Application by Snowdonia Pumped Hydro Limited for an Order Granting Development Consent for the Glyn Rhonwy Pumped Storage Scheme

Request for further information schedule

Issued on 20 July 2016

Figure 3.3: Nuttall's waterweed control options decision tree

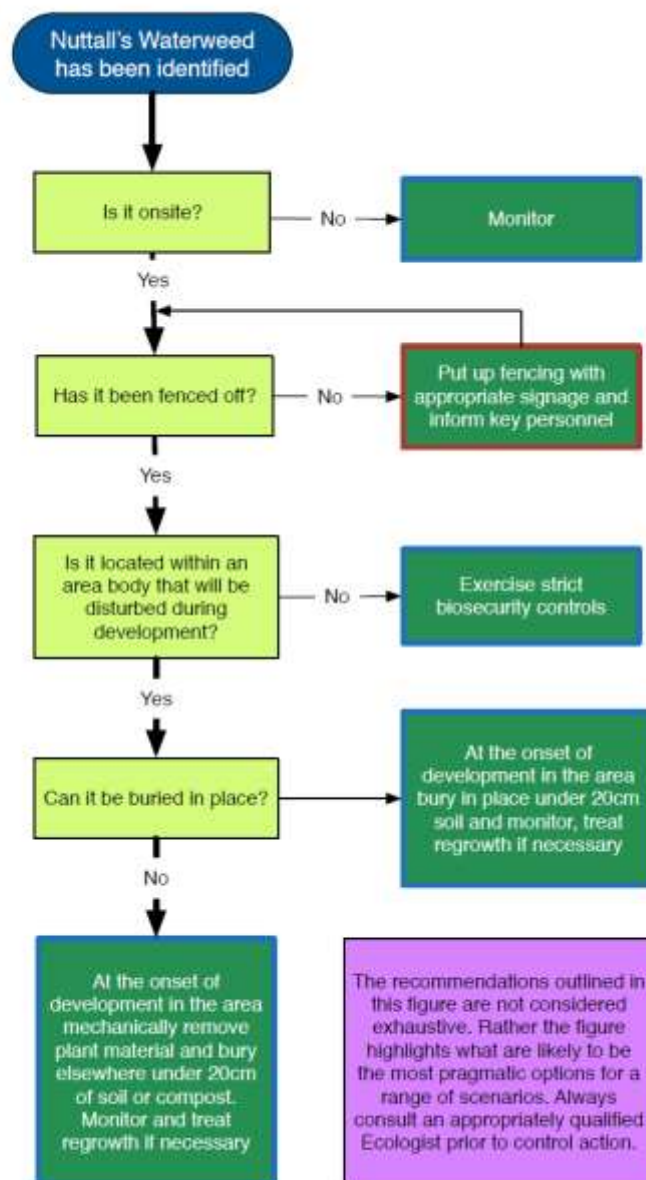
3.10.	Applicant NRW	a) Please clarify the risks of Nuttall's waterweed in Llyn Padarn being disturbed during construction or operation and the risks of it being abstracted to the reservoirs, either during the initial filling or in the future. b) Please could the specific relevant mitigation measures be described more fully in the outline Biosecurity Plan [REP5-022, section 3.6]?
